Engineers Comments Regarding Surface Water Drainage - Condition 10

It is recommended that condition 10 imposed under AL/28/21/PL is discharged. All surface water drainage is to be constructed in accordance with the following plans:

- Proposed Drainage Layout Sheet 1 of 2 C1967 100 Rev P1
- Proposed Drainage Layout Sheet 2 of 2 C1967 100 Rev P1
- Proposed Construction Details C1967 500 Rev P1

Application No: AL/55/22/DOC

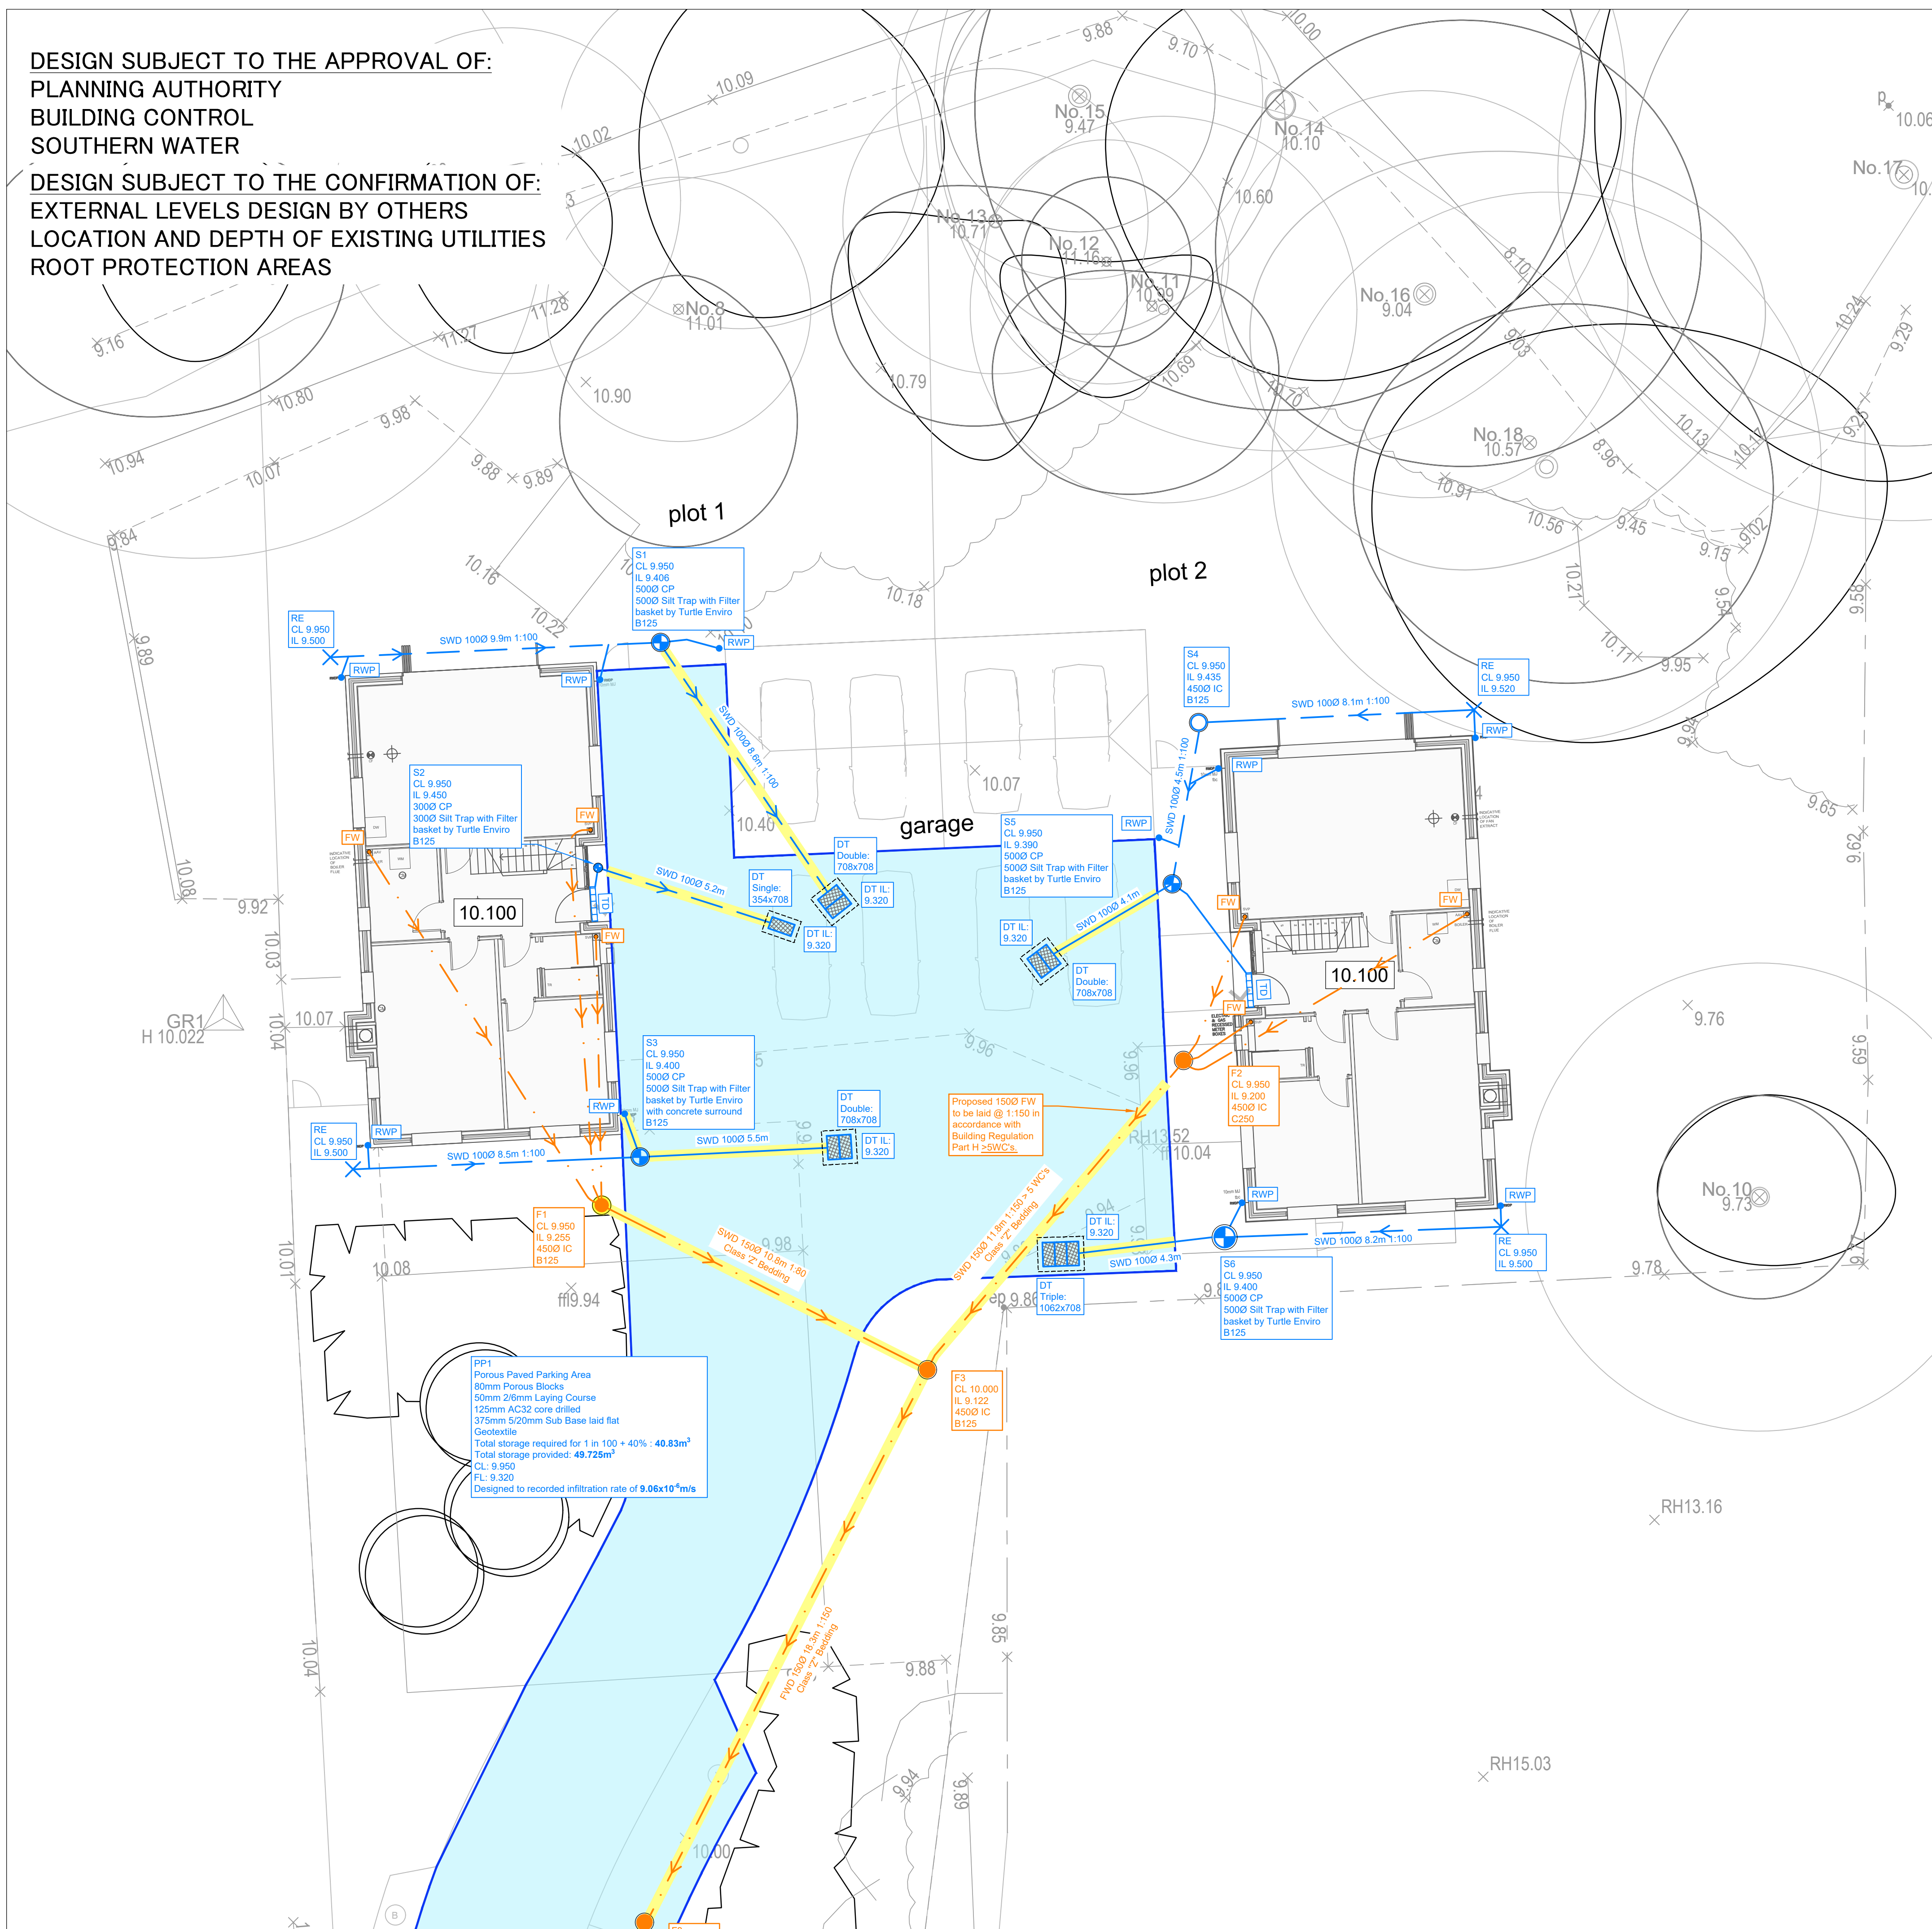
2. Please include a scale bar on the drainage layout so impermeable areas and diffuser distances from structures can be checked. Alternatively please show measurements for the same purpose. Please find updated drawing attached. Thank you – point closed.

- a. Please include pipe gradients. Almost all gradients given – some not between the silt traps and the diffusers – however invert levels are given at each end. Not considered enough of a fault to warrant refusal. Point closed.
- b. Diffuser blocks should be set above the 1 in 10 year +40% critical storm event. They are currently set below the formation level of the permeable paving (diffuser inverts at 9.350 – permeable paving formation at 9.370). These should also be located a minimum of 5m from all controlled structures, see point 3. Please correct.

- c. It is not clear why there are apparently random dotted lines on the drainage layout, please can their use be clarified or they be removed. The dotted lines on the drainage layout around the diffuser tanks are indicated on drainage legend. I think this was an issue with the file being corrupted or our viewer rather than the layout itself. Point closed.
 - d. Please detail sump depths for catchpits. Not given. However, the pre-fabricated catchpits are listed which have a standard sump depth of 330mm – these are acceptable. Please ensure sump depths are listed on any future submissions. Not considered enough of a fault to warrant refusal. Point closed.
5. Please amend Typical distribution Tank Outflow Detail to show all diffuser blocks above the 1 in 10 year + 40% critical event as per point 4b. See 4b reply. As above.

The proposed diffuser block has been relocated minimum 5m away from the proposed structures. The proposed diffuser tanks act as an outlet (discharge) connection into the subbase formation. We do understand that incoming pipe IL should be set above the 1 in 10 year + 40% CC level for the traditional soakaway system, however the proposed surface water runoff will be discharged into the voided subbase and therefore to achieve this, the proposed subbase IL will need to be dropped by approx. 300mm. This will make the proposed subbase 600mm deep and due to the associated costs not viable. We could propose using a traditional soakaway system however, noting the groundwater levels surface water runoff will therefore need to be attenuated and discharged into the onsite foul drainage system. By doing this, there is a risk of the proposed SW discharge into foul drainage network being refused by statutory undertaker.

The proposed drainage system has been designed so the surface water level for the 1 in 10 years + 40% is below the proposed access points (rodding eye) ILs.

Furthermore, the proposed FFL has been set at min. 300mm above the top of the proposed voided subbase and the maximum surface water level for the 1 in 100-year rainfall event + 40%CC + 10% UC. Discussed with the Principal Drainage Engineer and he is satisfied with the response. Point closed.

Proposed permeable block paving
typical construction

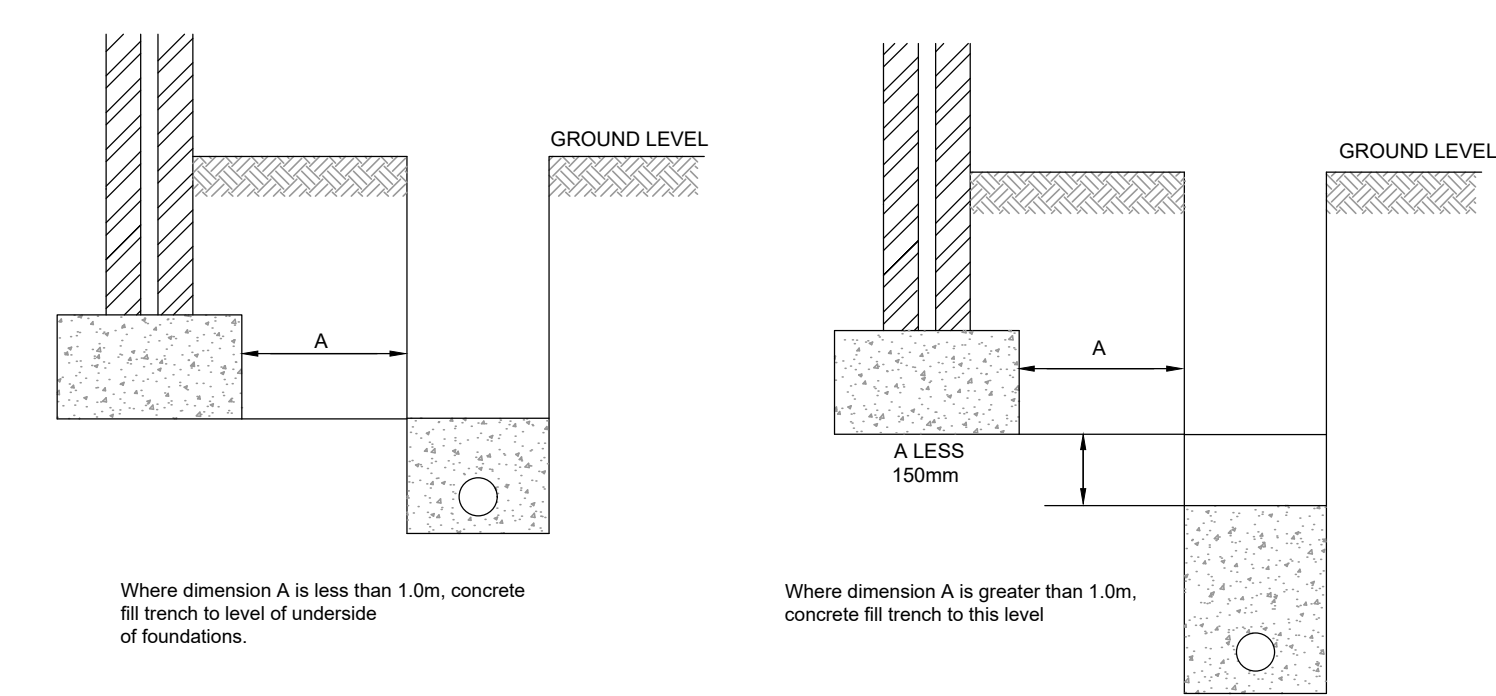
- h. The permeable paving invert level is set to 0.380, yet formation level is shown as 9.370 on the drainage layout. The value of 9.370 corresponds with the formation shown in the construction details, therefore please correct the calculations to reflect this. The proposed voided subbase has been updated and is now 375mm thick so the permeable paving subbase IL is now set as: 9.320 Thank you – point closed.

- i. Slope is listed as 1:800 but on the drainage layout it is stated that sub base is laid at 1:500. Please correct. Please find the updated drainage calculations attached. It is proposed that voided subbase is now laid flat. Thank you – point closed.
